Yorkshire Green Energy Enablement (GREEN) Project

**Document 8.28 Applicant's Comments on Interested Parties' Deadline
5 Submissions**

**Final Issue A
July 2023**

Planning Inspectorate Reference: EN020024

NATIONAL GRID (YORKSHIRE GREEN ENERGY ENABLEMENT PROJECT)
 ILLUSTRATIVE PLAN: SP005 ACCESS DURING CONSTRUCTION PHASE - OVERTON
 REGULATION 5(2)(o)
 SHEET 1 OF 1

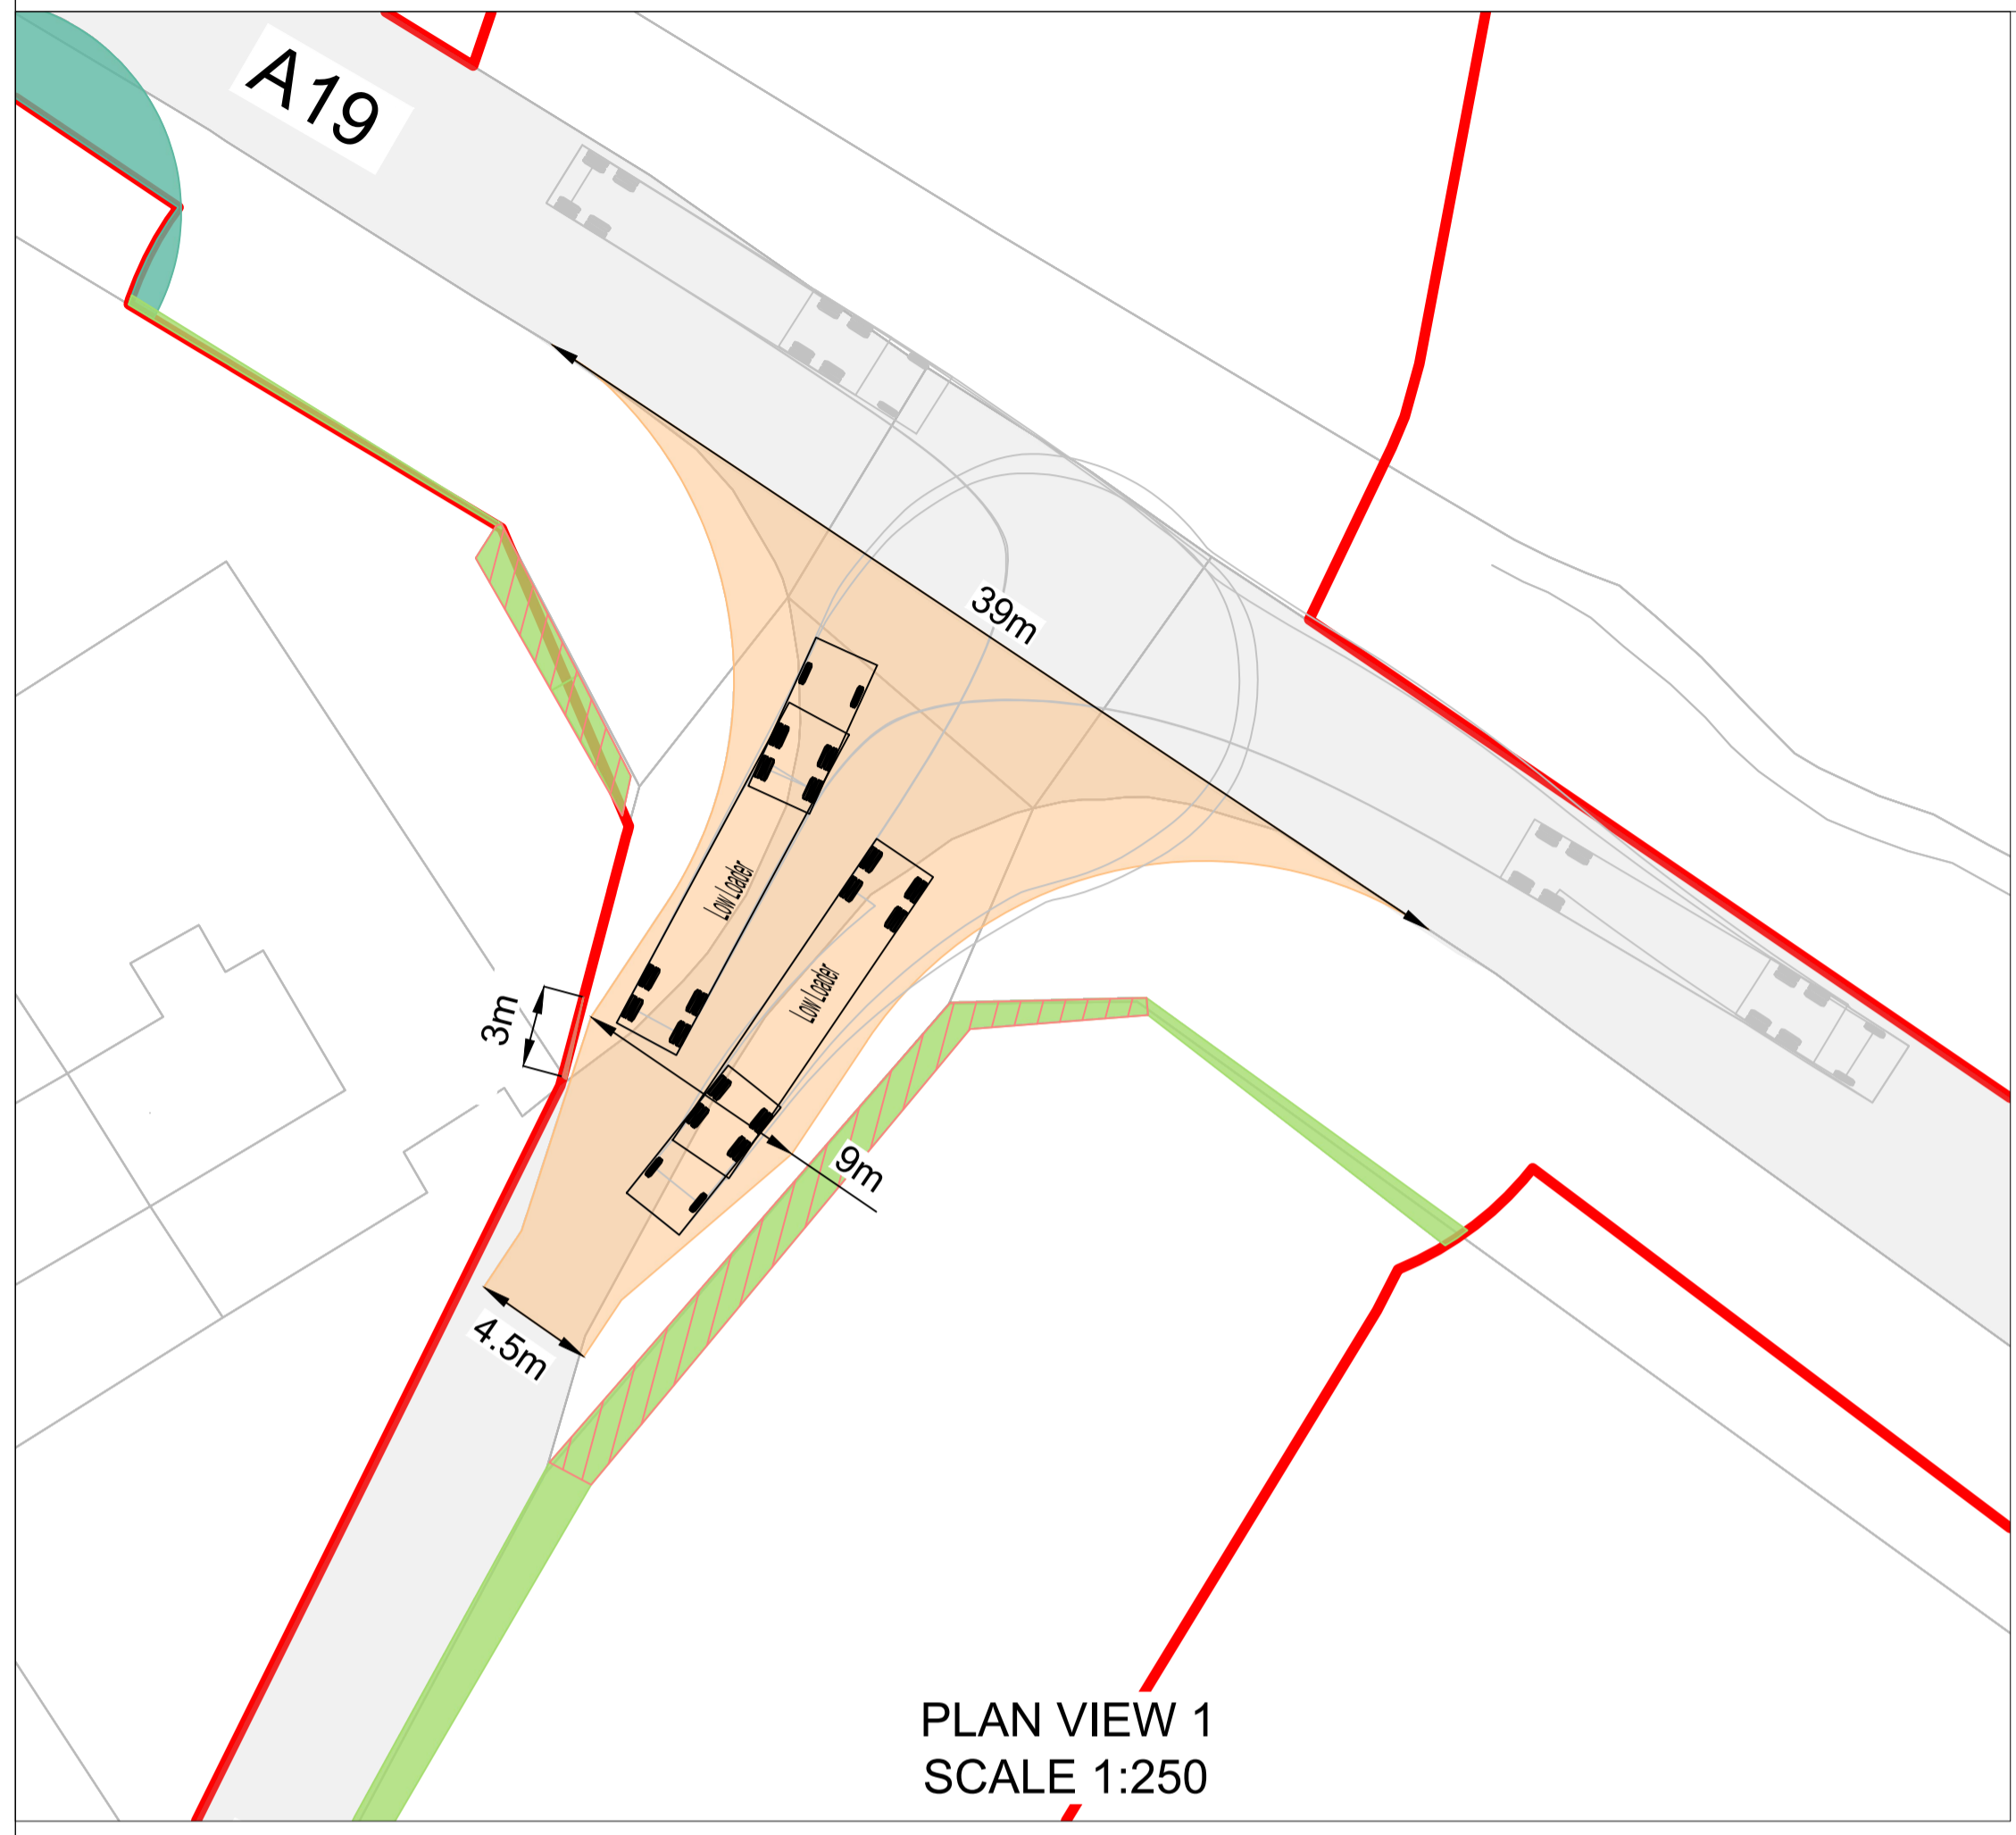
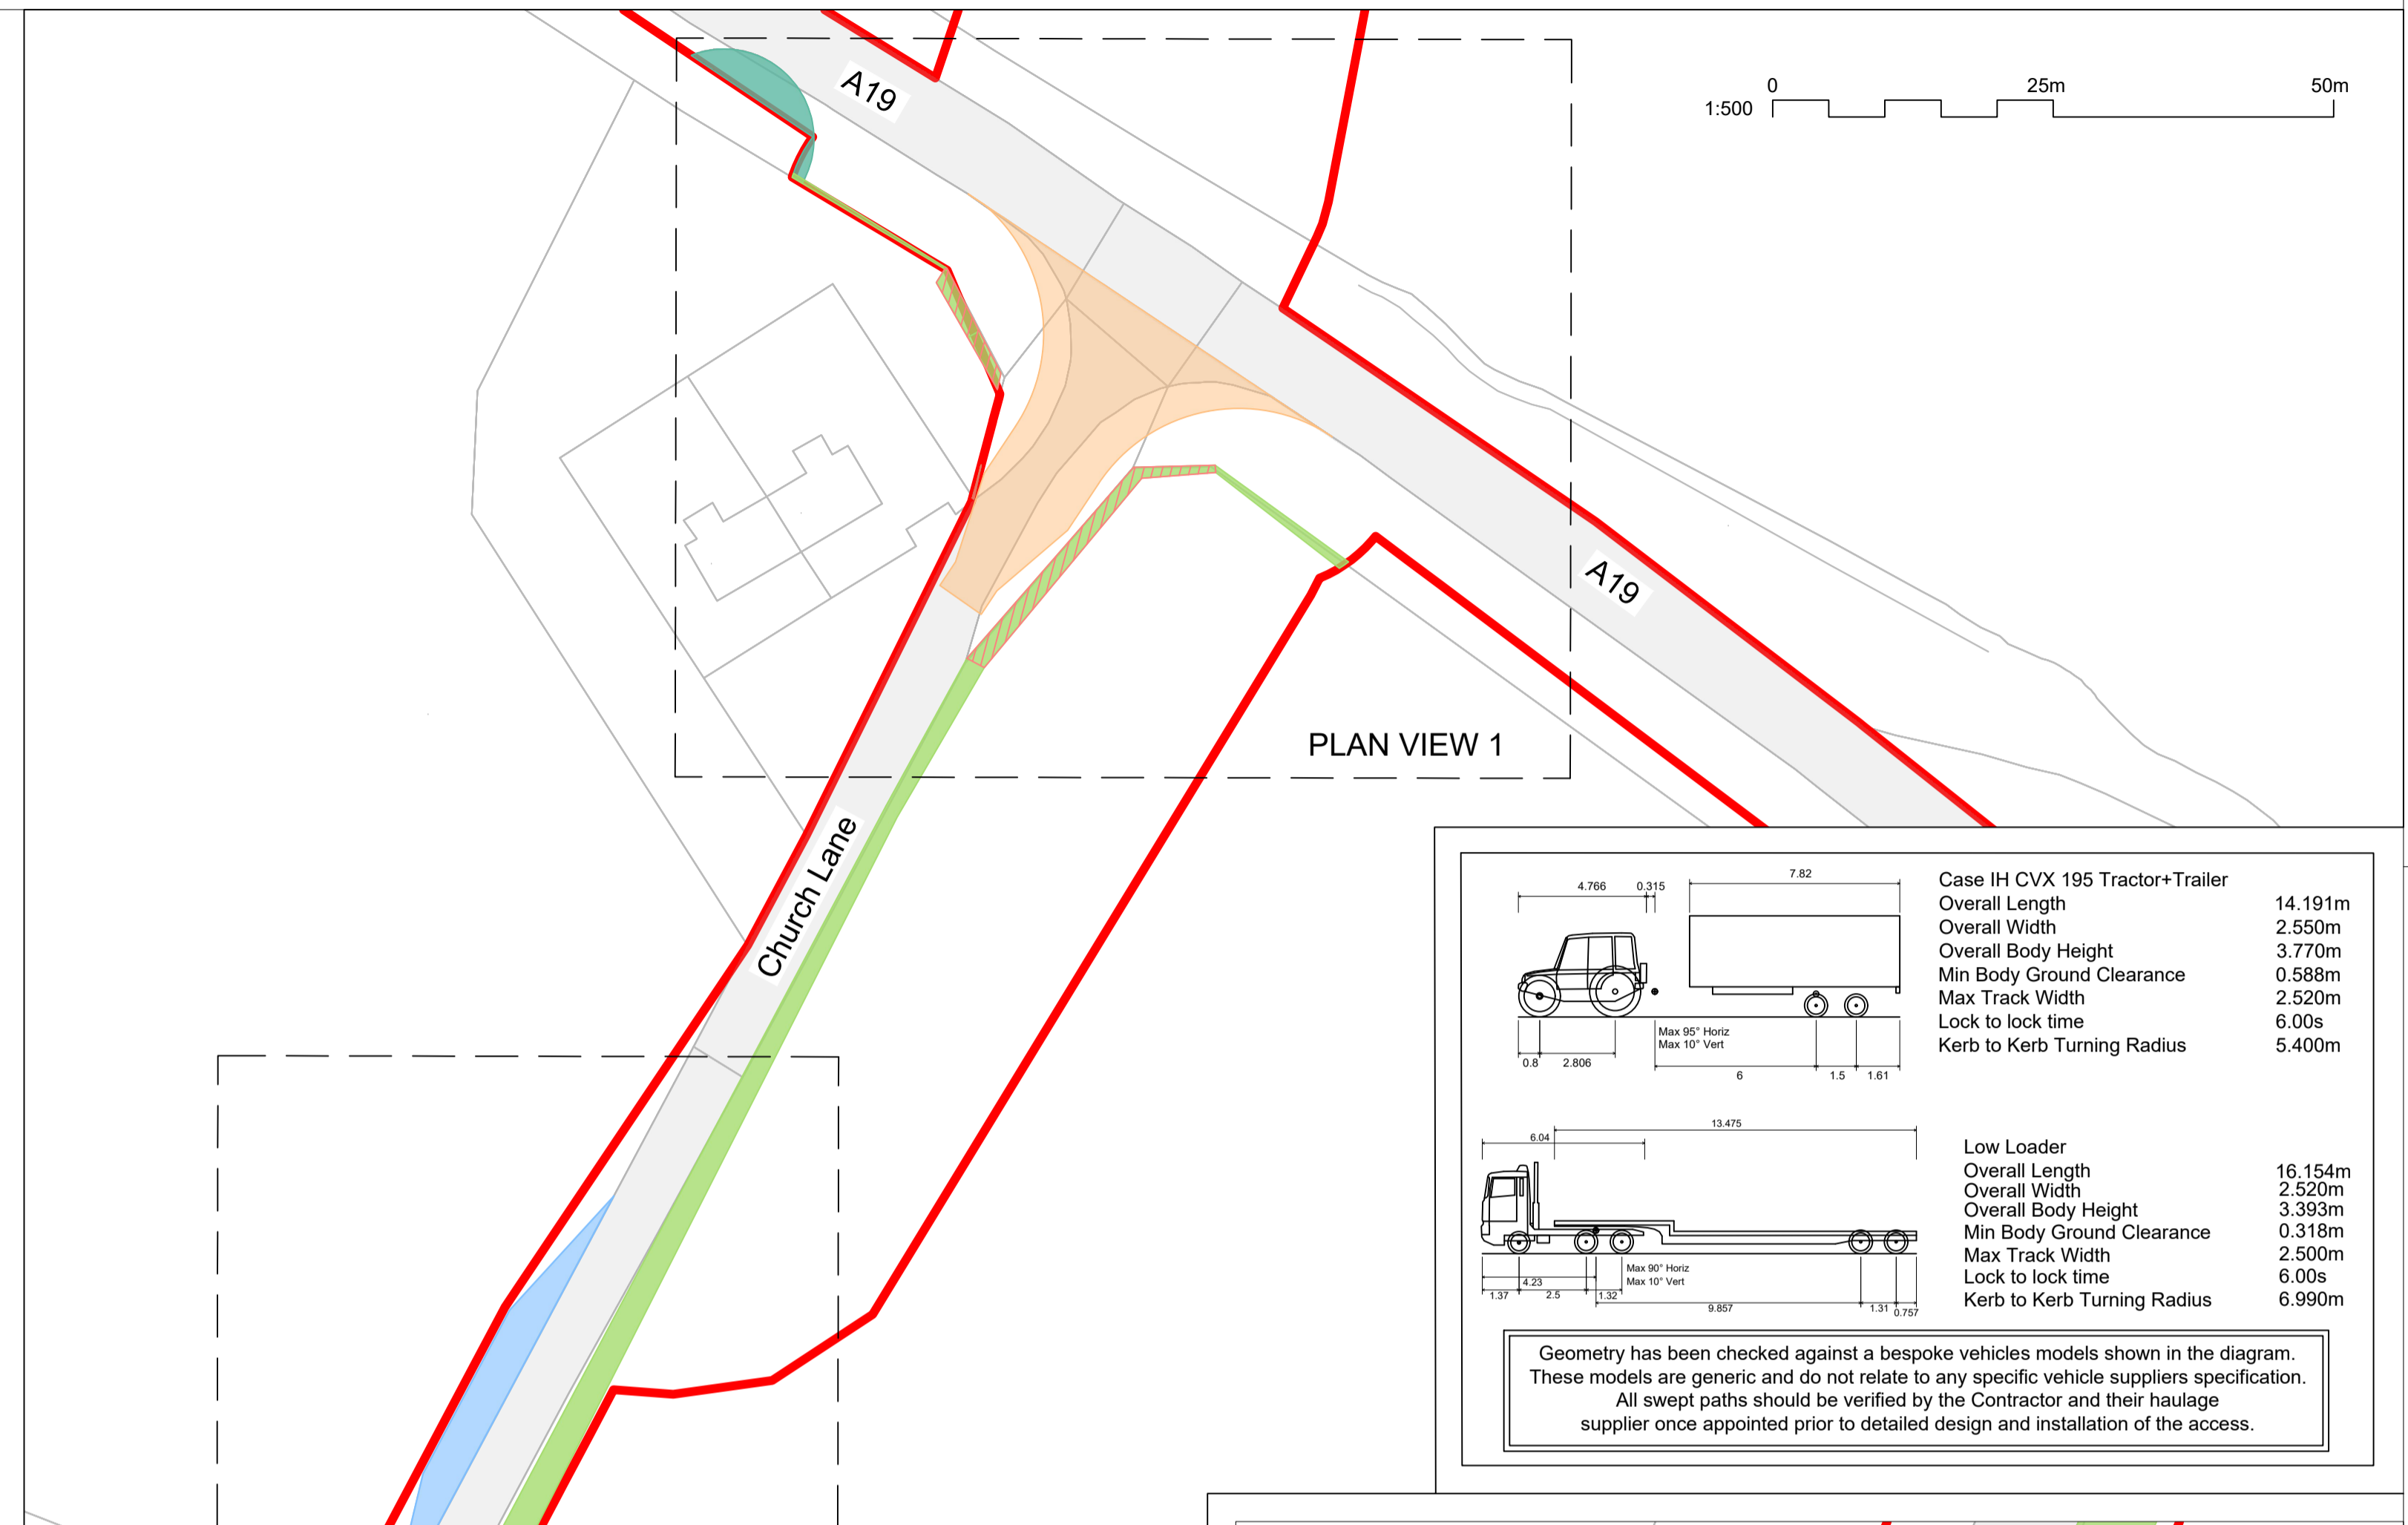
Reference	Topic	Applicant’s Response
Q1.3.2	Illustrative Plan: SP005 Access During Construction Phase [REP4-026], Appendix D	<p>National Grid seeks to clarify that the plan submitted within Appendix D of [REP4-026] was intended to illustrate potential access road passing places only and was not intended for any other purpose.</p> <p>However, in response to the comments received from City of York Council (CYC) (stating that detailed construction drawings will be required [REP5-101]), National Grid confirms that engagement between both parties is ongoing, and as per the Statement of Common Ground (Document 8.5.4(C)) [REP5-033] there are no outstanding issues between the parties relating to transport matters.</p> <p>For clarification purposes, for any proposed accesses in the CYC area there will be consultation at the detailed design phase between National Grid and CYC, and this will include the production of detailed drawings.</p> <p>Requirement 14 of the Draft DCO (Document 3.1(D)) [REP5-004] details that construction of vehicular access cannot commence until the access layout and design has been submitted to and approved by the local highway authority. The Local Highway Authority will have the ability to control the required Licence or Agreement arrangements as part of this process.</p>
